Application No: AB/114/20/PD

Site Address: Riverside House 2 Fitzalan Road Arundel BN18 9JS

Description of works: Notification for Prior Approval under Schedule 2 Part 1 Class AA for a additional 2 storeys on existing dwelling house.

Drawing Title:
PROPOSED ELEVATIONS

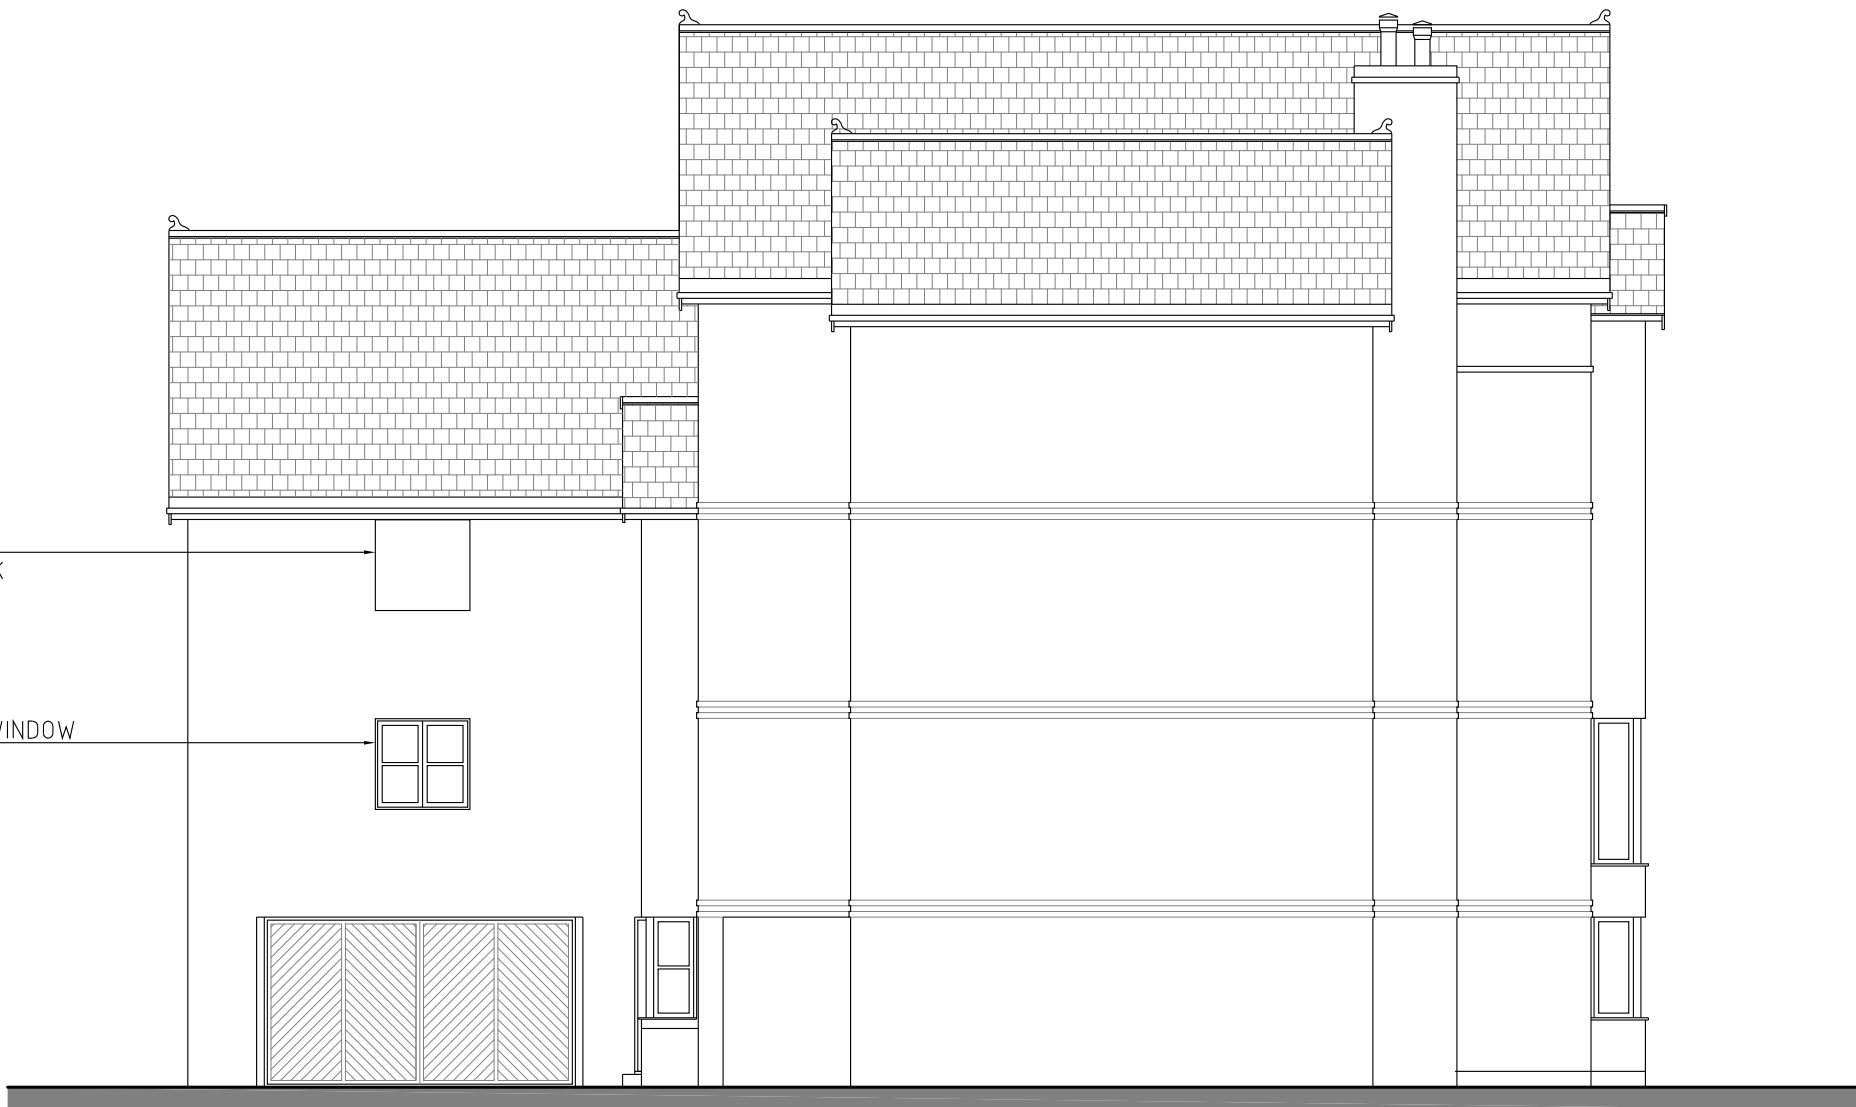
The Committee objected to the Application on the grounds that the proposal would result in a large bulky 4 storey property that would extend almost the full width of the plot and appear intrusive in a street scene where other dwellings are of a more discreet and smaller scale in appearance.
